THE VINERY, POLING

Thank you for inviting views on the planning application A/74/13 which seeks planning permission for a proposed distribution warehouse and covered storage, trade counter and associated offices. The application includes the upgrading of the access road and improvement of the existing junction with the A27. We note that this application is a departure from the Development Plan and also affects a public Right of Way.

**THE VINERY, POLING
HIGHWAY LAYOUT AND ROAD SAFETY**

TECHNICAL NOTE 01

CLIENT	
DRAWING	
EXISTING AND PROPOSED ENTRANCE LAYOUT	
DO NOT SCALE FROM THIS DRAWING. THIS DRAWING IS COPYRIGHT ©

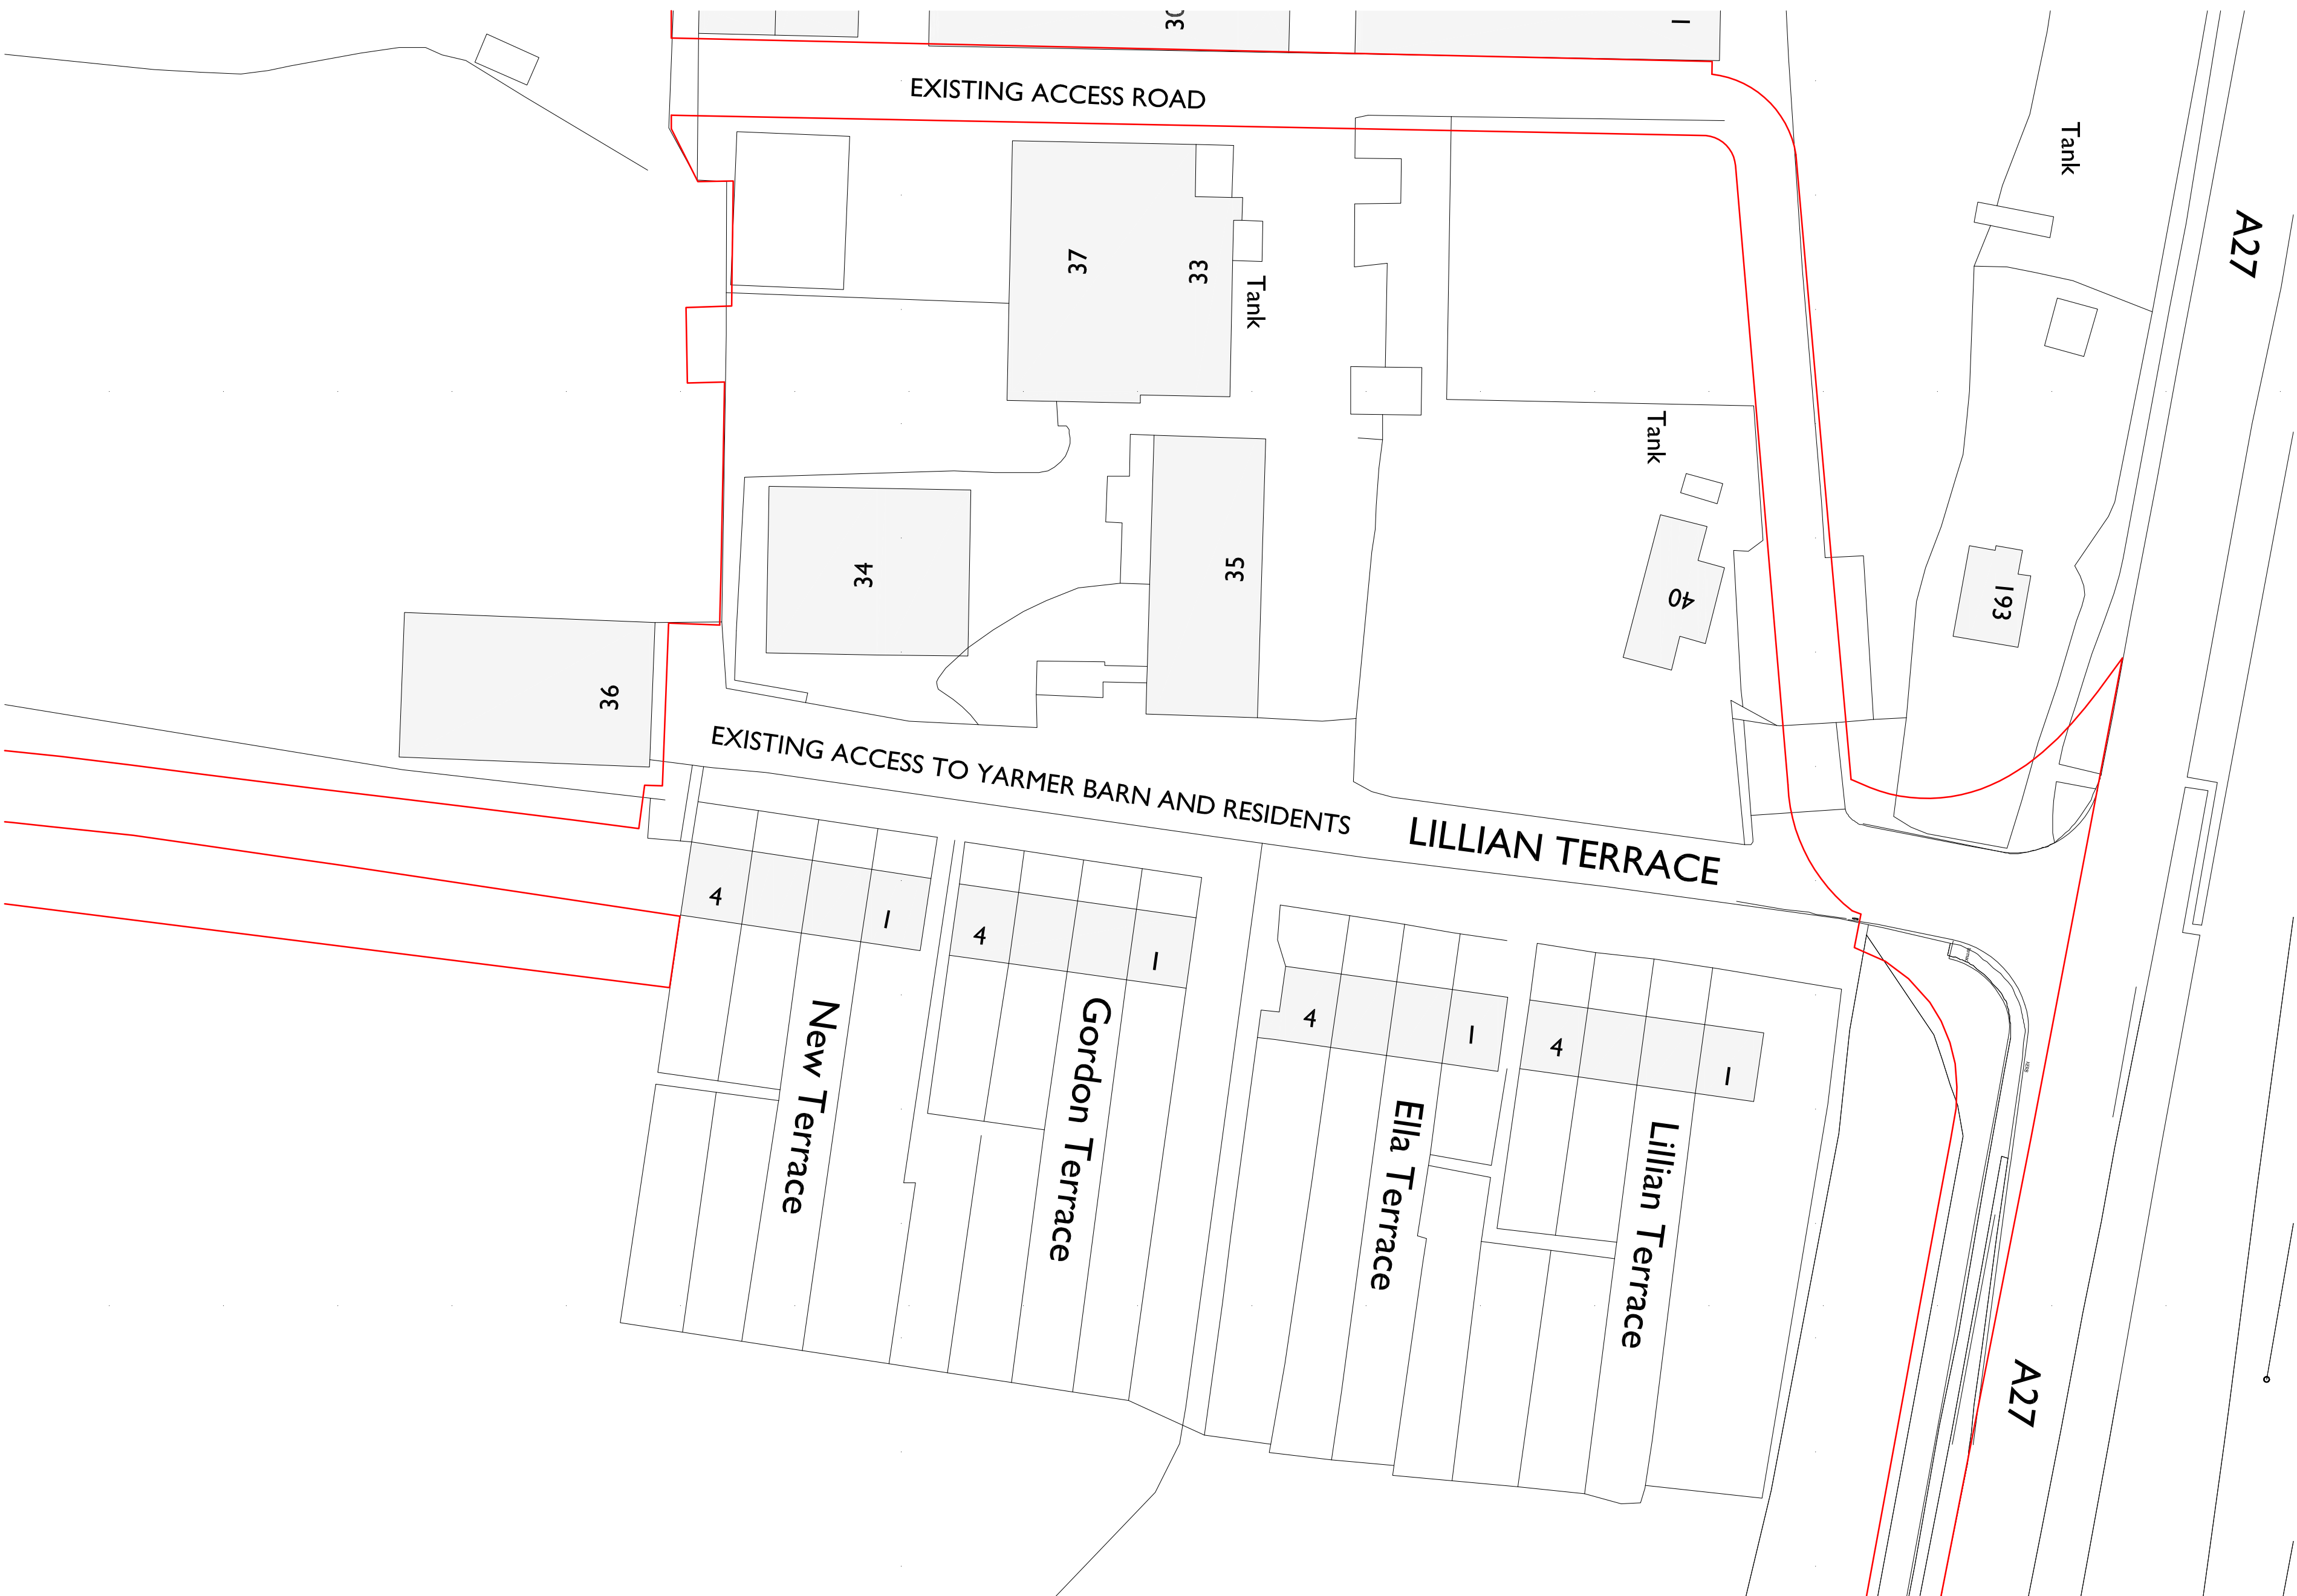
2.1.1 Sight Stopping Distance requirements set out TD9/93 (as amended) are achieved on the approach to the junction.

2.1.2 Visibility from the side road as listed in TD42/95 Table 7.1 is achievable from a distance of 9m set back from the channel line, provided that the vegetation within the verge to the east of the junction is removed and maintained as grass.

2.1.3 Visibility of the junction form from 15m set back is achievable but will require vegetation removal over a wider area.

- 2.1.4 The pedestrian and cycle route has been set back further into the junction and the visibility of the entire length of the diverge taper should be visible from this point for safety reasons, and the area of the verge where the vegetation should be removed will need to be measured from this point.. An NMU context report should be provided as this will be an inconvenience for pedestrians and cyclists using this route, causing them to deviate from the direct route.

- 2.1.5 The proposed radii of 20m are in accordance with TD42/95 para 7.17.
- 2.1.6 The length of the exit taper at 80m is one step below the deceleration length set out in TD42/95 table 7/5b. This is a substantial improvement over the current situation of 48m, which is between 2 and 3 steps below. The Transport Context report states that current permissions at this site required a taper length of 55m, being 2 steps below, however this was appealed successfully and the taper at 48m would remain under the existing planning consent. Under these circumstances the proposal to provide a diverge taper of 80m as part of a development where there would be less traffic generated than the current permission includes, this is considered to be acceptable.

- 2.1.7 A channelising island in the side road has not been provided within the design and does not exist in the current layout. Where this is not provided, para 7.24 suggests that the nominal approach width should continue up until the tangent point of the curve to join the edge of the major road running carriageway. The approach width of The Vinery is less than 7m, but at the point where the access road joins it is approximately 10m wide, which in turn creates an overly wide crossing point for pedestrians and could encourage vehicles to turn in from the A27 at high speeds. It is suggested that the widened radius curve on the entry to the A27 (i.e. the west side of The Vinery) is moved approximately 2.5m to the east to provide a narrower junction. This is illustrated in the sketch below:

2.1.8 The sketch shown the same radii linking the access road to The Vinery (6m) and The Vinery to the A27 (20m), reducing the width at the pedestrian crossing point to approximately 7.3m. In a reduction of the area to be constructed as new carriageway and a reduction in land take from the property to the west of The Vinery.

- 3.1.1 The proposal to improve the junction is broadly acceptable in its compliance with highway standards, subject to the improvement of sight lines within the visibility envelope by the removal of vegetation from the existing verge.
- 3.1.2 A suggestion to reduce the width of The Vinery has been put forward for consideration, that will reduce the width of the road on the approach to the junction and reduce the pedestrian and cycle crossing point.
- 3.1.3 An NMU context report is required in connection with the relocated crossing point.
